Case Officer: Lewis Knox

Recommendation: Approve

Proposal: Demolish garage. Replacement roof (eaves and ridge to be as existing).
Erection of single storey and two storey extensions to front, side and rear. Enlargement of parking/turning area.

19-08-02 PE Ver.4

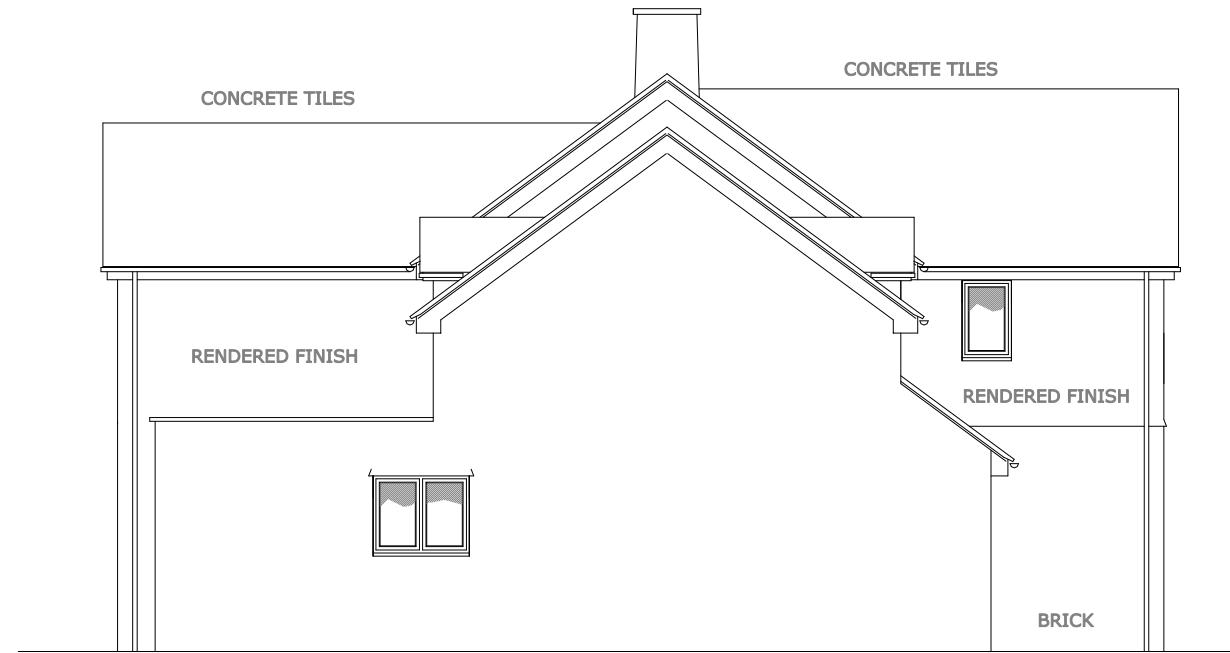
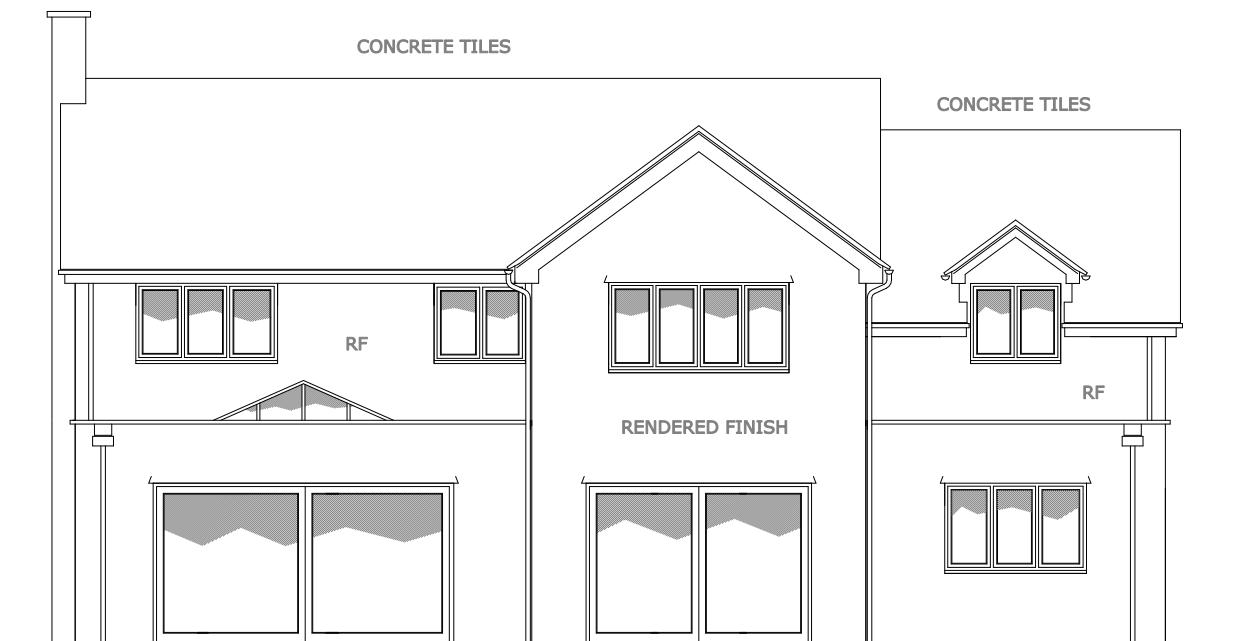
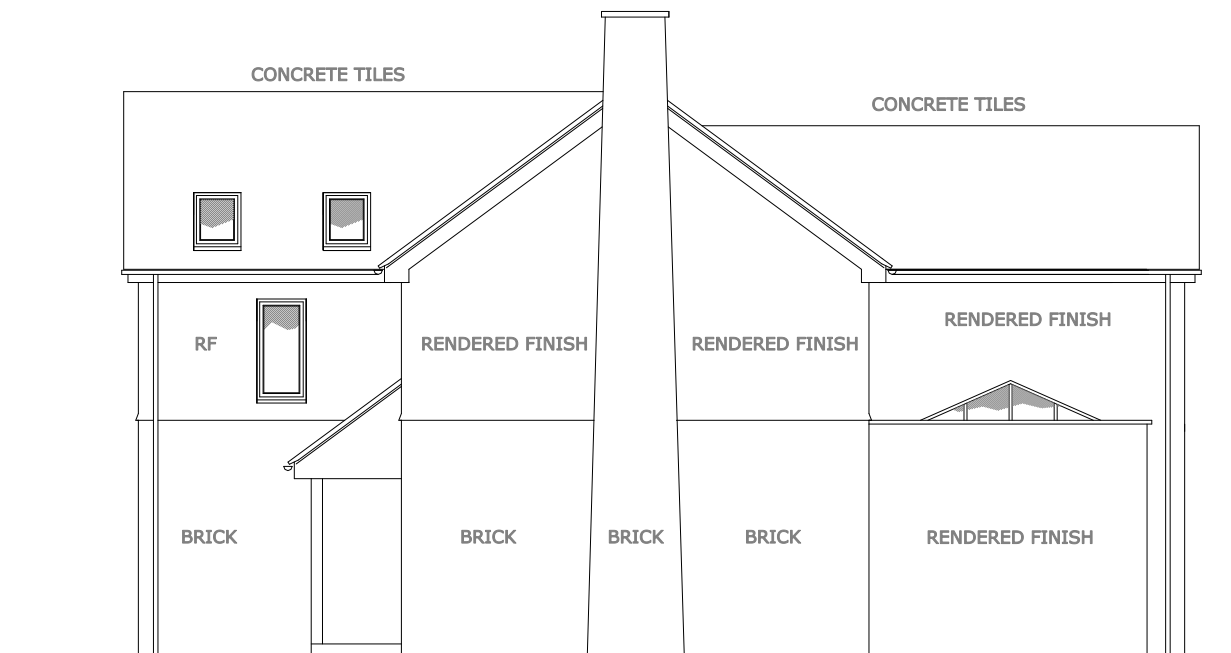
- 8.4. The two storey front extension, rebuilding of the garage and extension over the garage would all be visible from the public domain and would therefore have an impact on the character and appearance of the streetscene.

- 8.5. Two storey front extensions of this size are generally considered to be beyond what is appropriate at a standard dwelling, however it is noted that two of the neighbouring dwellings to the north (9 and 11 Blackwood Place) have previously completed similar developments. It is therefore considered that the proposed extension would continue the established character of the area which has been set by the two dwellings immediately north of the site.

- 8.6. The rebuilding of the garage and extension over the top would further continue the established character of the eastern side of Blackwood Place with other neighbours incorporating their garages into the main dwelling. The first floor extension would be subservient to the main dwelling in order to respect the original scale of the dwelling.

- 8.10. The materials proposed for the extensions are red brick and render which would match what currently exists at the dwelling and so the existing character would be retained. The windows are proposed to be powder coated aluminium which would be an improvement on what currently exists. The proposed materials are considered to be appropriate for this development.

DRAWING NUMBER  
19-08-02 PFP Ver.4

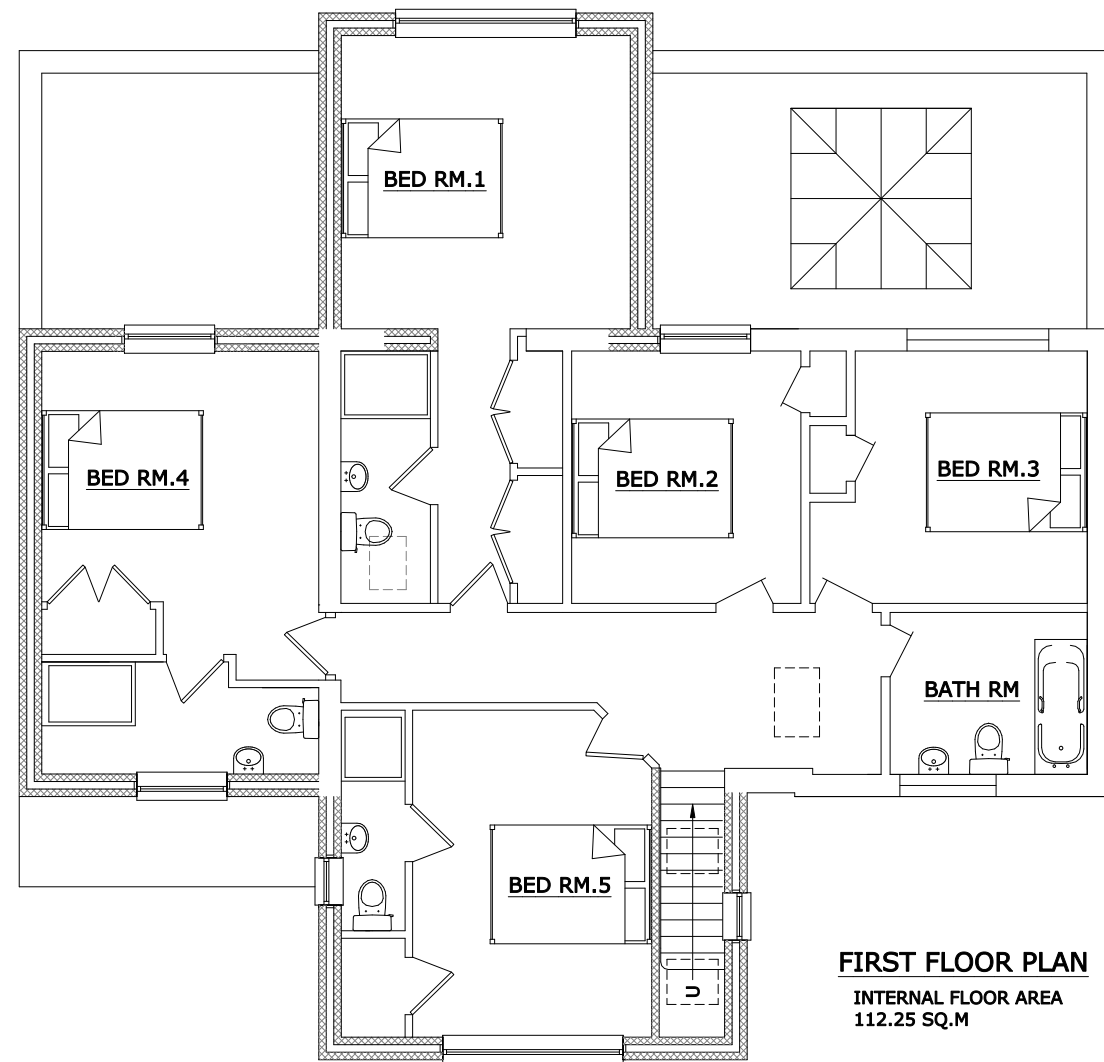
- 8.16. The only proposed openings which would face the neighbouring properties to the north or south would be on the first floor of the two-storey front extension. These windows would serve a stairwell and an en-suite bathroom and not any principally habitable areas and so would not impact on the levels of privacy in the locality.

- 8.19. The proposed extensions would increase the number of bedrooms at the property from 3-5. Despite this increase it is considered that sufficient off-street parking provision would be retained at the site for a dwelling of this size. The site benefits from a large front driveway with hardstanding which would be increased through the development. The garage at the site would also be retained.
